**Planning Department
Transportation Development Services**

March 03, 2015

**Re: Applebee's, 98th St.
Traffic Circulation Layout**
Engineer's/Architect's Stamp dated 2-27-15 (K09-D038)

Traffic Circulation Layout

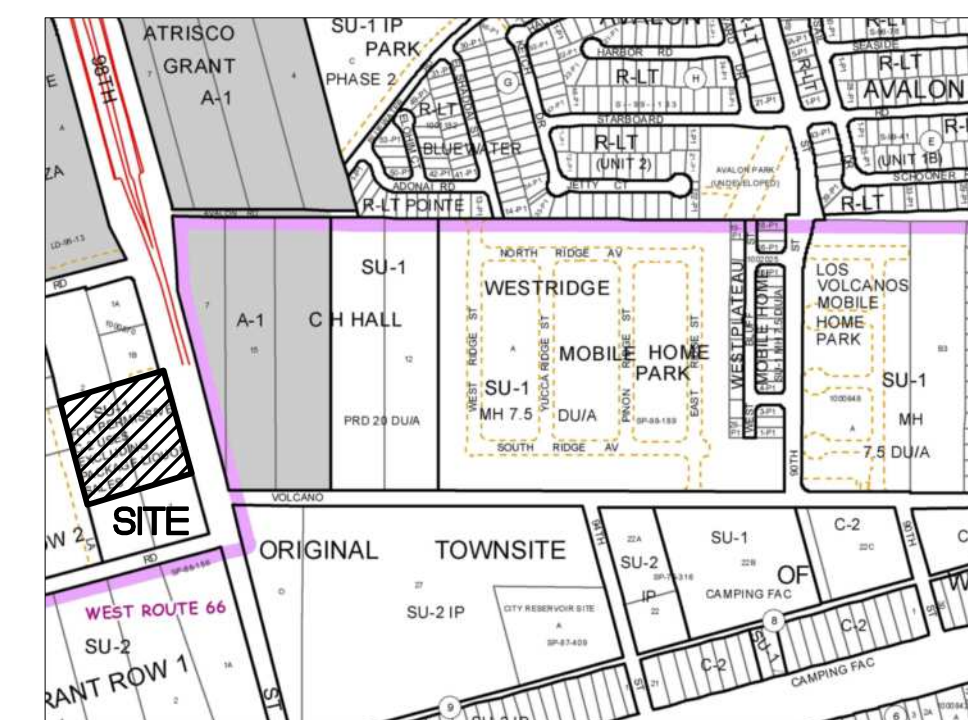
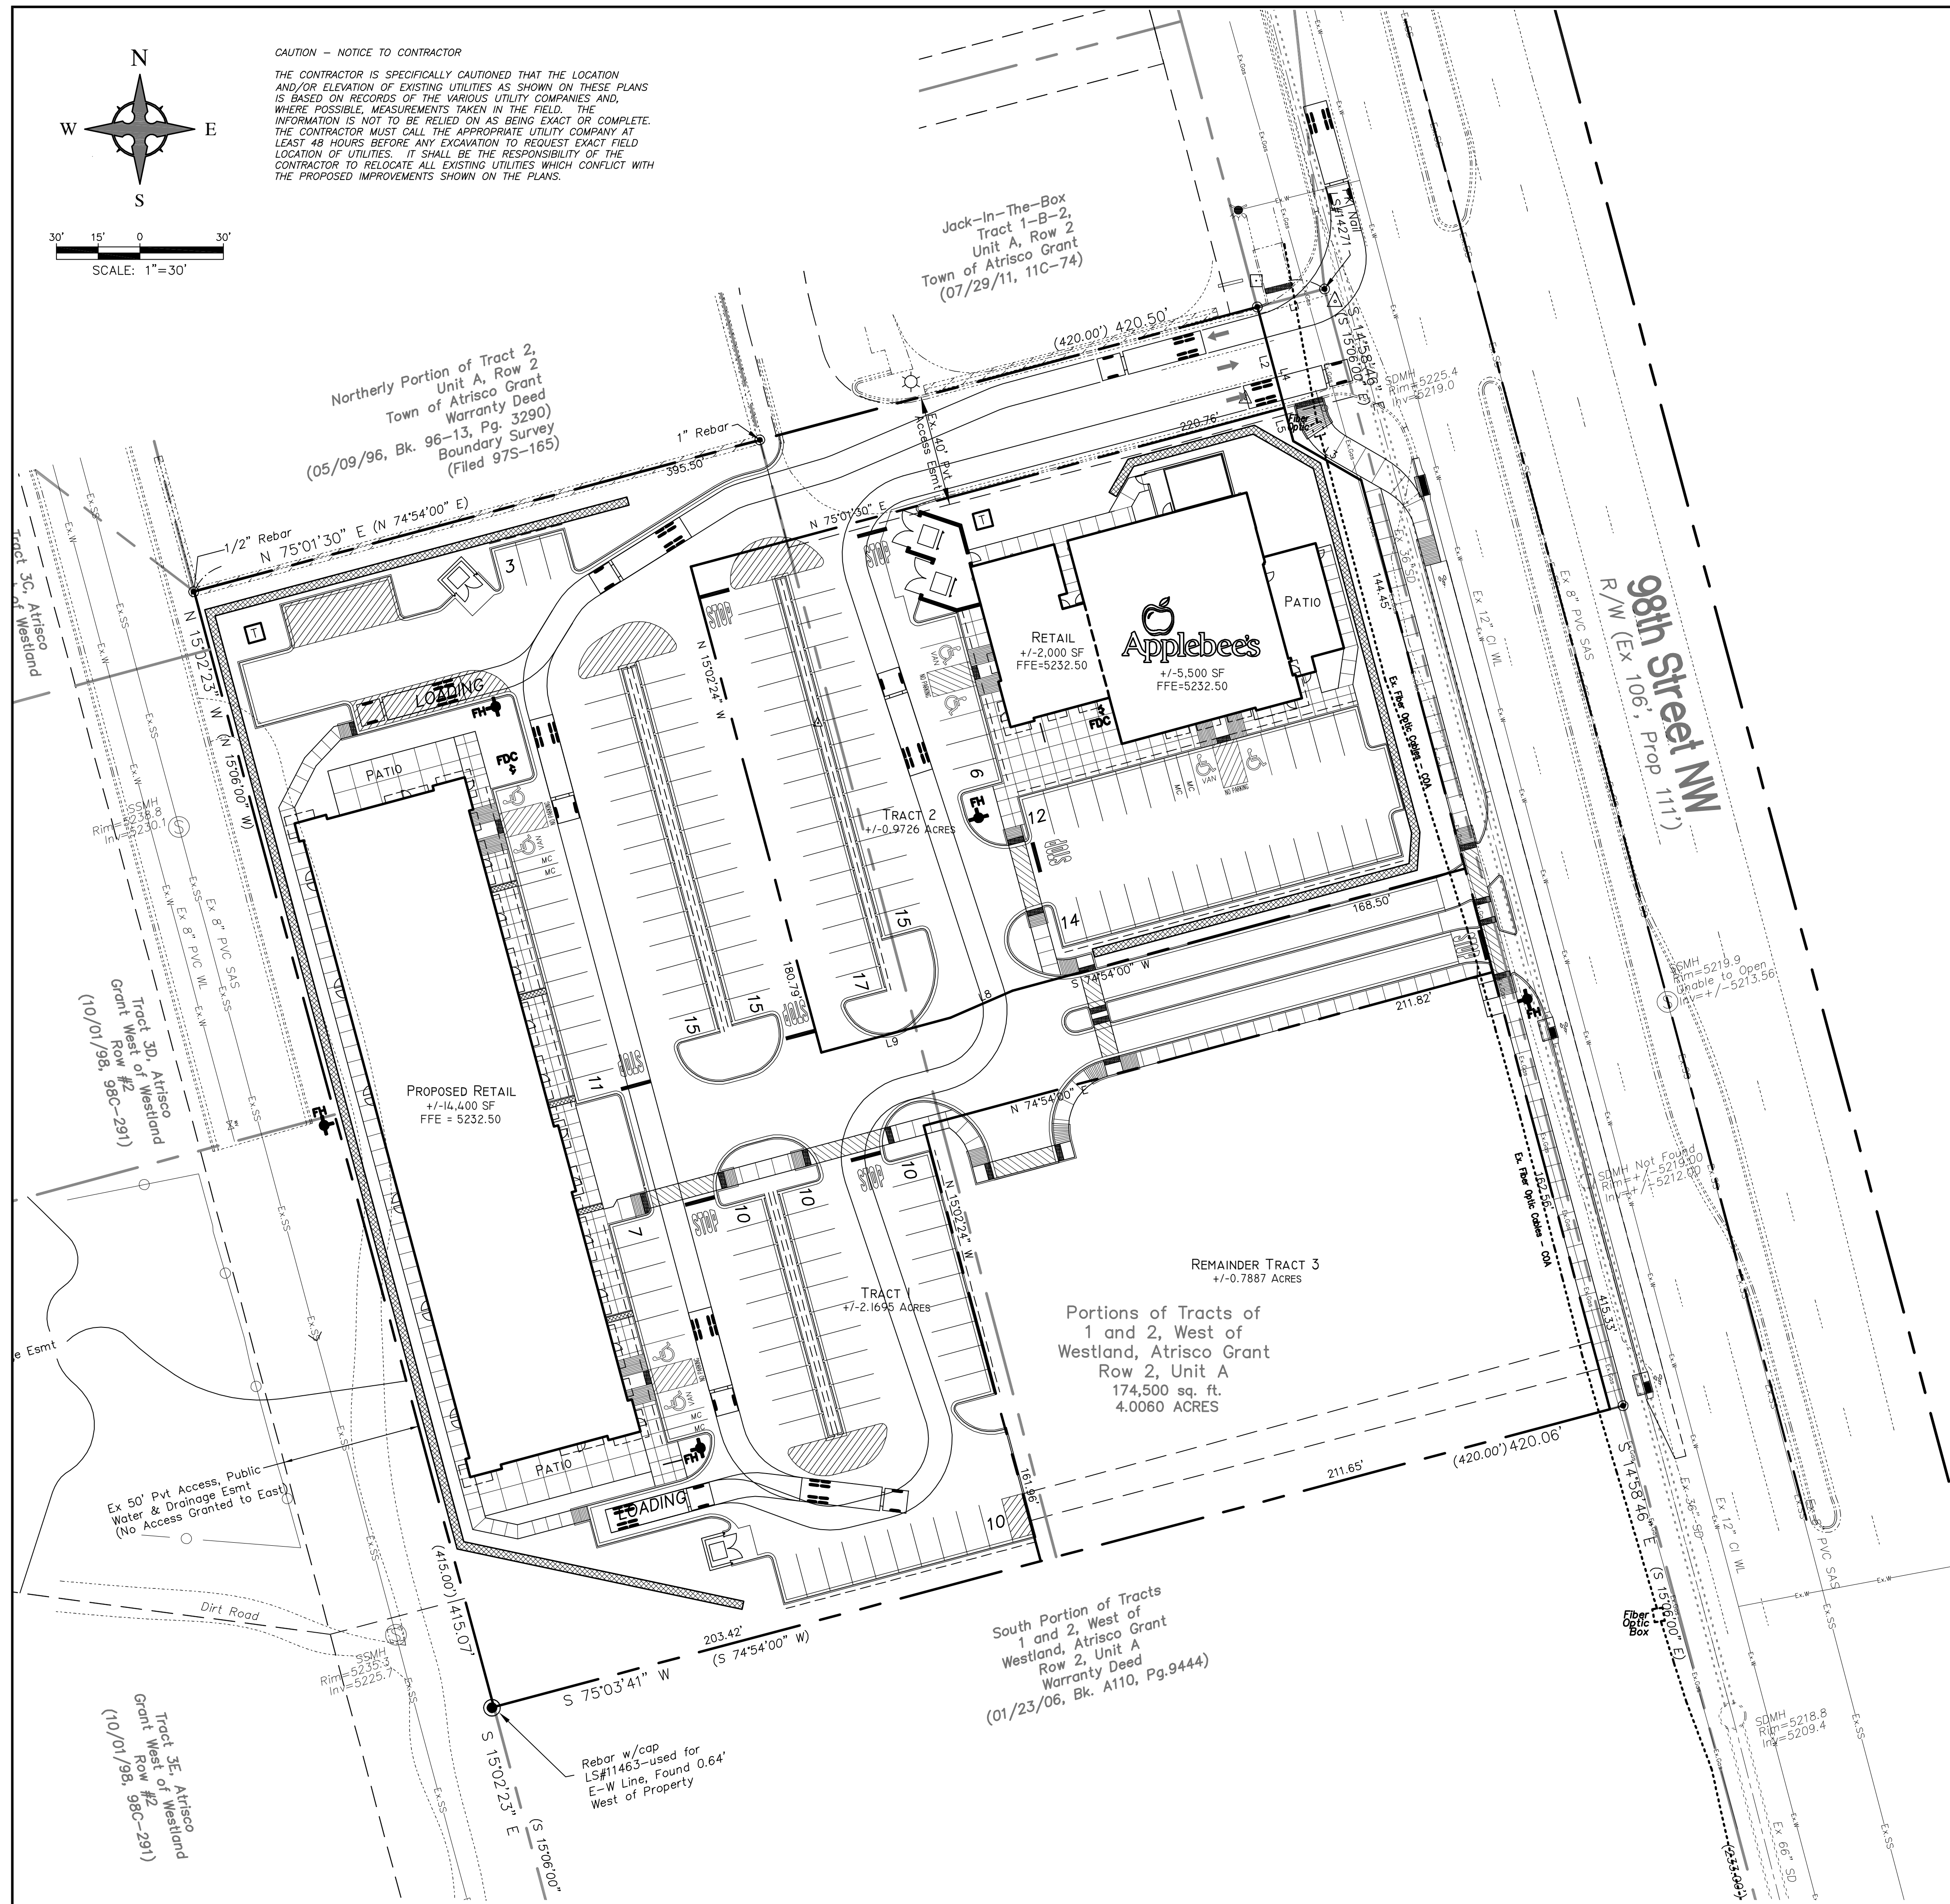
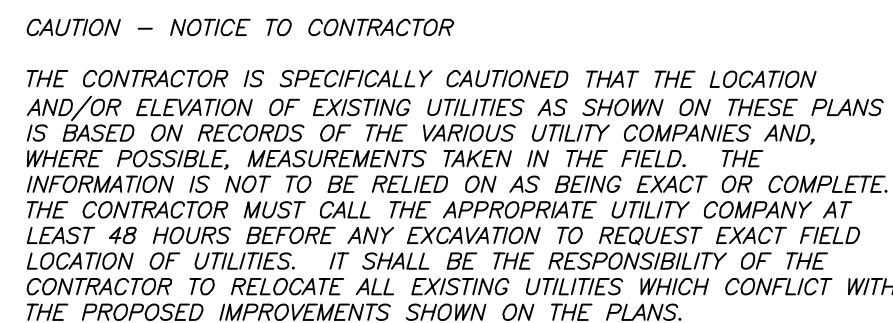
1. The proposed development looks like it may meet the threshold for a Traffic Impact Study based upon the combined square footage of the Applebee's and proposed adjacent retail site. Provide a trip generation.

2. For next submittal, please provide site address and/or legal description.
3. On next submittal, please label drawing as "Traffic Circulation Layout" in lieu of "Site Plan".

4. Provide separate D.R.C. drawings for outer curbs on 98th St. R.O.W. On the Traffic Circulation layout, provide a dimension from the median curb to the proposed curb, and label lane widths for southbound traffic on 98th Street.

5. Subject site entrance off of 98th St. must have a 5 ft. keyway for vehicles backing up out of parking spaces shown at Keyed Note 10. In order to accomplish this requirement, the developer may reduce parking space width to 8.5 ft.

6. The ADA van accessible sign must have the required language per 66-7-352.4C NMSA 1978 **"Violators Are Subject to a Fine and/or Towing."** Please show detail on drawing.

7. The ADA van accessible aisles are required to be a minimum 8.5 feet in width. Label these widths on the site plan.
8. The ADA access aisle shall have the words **"NO PARKING"** in capital letters, each of which shall be at least one foot high and at least two inches wide,

9. Parking spaces must be a minimum of 18 ft. in length. Proposed drawing shows all spaces as 16 ft. in length. Per code, "Compact Parking" shall only consist of one-third of the total number of parking spaces, excluding number of handicap parking spaces. Either increase the parking space length to 18 feet while maintaining the 24-foot wide parking aisle, or call out a 2-foot overhang over the islands to satisfy the 18-foot requirement. For all parking spaces that are kept compact, list them as "Compact".

10. Label curb radii for all curves shown; for passenger vehicles, the minimum end island radius is 15 feet, but 10 feet is shown for many of these islands. Also show the 2-foot radii as applicable. (See Figure 23.7.2 of the DPM.)

11. Per the DPM, a 6 ft. wide ADA accessible pedestrian pathway is required from the HC parking stall access aisles to the building entrances. Please show detail on drawing. Please show detail for call-out notes #5 and #25 for curb ramps, showing all details including the maximum 12:1 slope for the ramp, the maximum 2% cross-slope and all necessary dimensions. (In order to meet this requirement, a 6-foot wide landing area is required at the top of the ramps from the parking lots to the proposed retail building. Otherwise, the ramp may be changed to the same style of the ramps in front of the Applebee's as long as they are 6 feet wide.) For the Applebee's ramps, call out the ramps to be a minimum of 6 feet wide.

12. Per the DPM, a 6-foot wide ADA accessible pathway is required from the public right-of-way to the building entrances. For all note call-outs for Note 12 for the pedestrian walkways only, label the dimension of the pedestrian walkway as 6 feet. Also, provide a minimum dimension of 6 feet behind the back of the ramp on the south side of the south entrance.

13. Label the existing curb ramp on the north side of the north entrance. Call out for truncated domes to be placed on this existing ramp.
14. Design delivery vehicle route needs to be shown.

15. For each of the two driveway entrances off of 98th Street, please provide a clear sight triangle. (see the *Development Process Manual, Chapter 23, Section 3, Part D.5 Intersection Sight Distance*).

16. Please add the following note to the clear sight triangle: "Landscaping and signage will not interfere with clear sight requirements. Therefore, signs, walls, trees, and shrubbery between 3 and 8 feet tall (as measured from the gutter pan) will not be acceptable in this area." (The signage called out by Keyed Note number 18 may interfere with this requirement.)
17. Label the recording information for the existing 40-foot access easement and DRB Case Number.
18. Platting action and infrastructure list must be finalized prior to approving Traffic Circulation layout with regard to proposed curb and sidewalk.
19. Please include two copies of the traffic circulation layout at the next submittal.
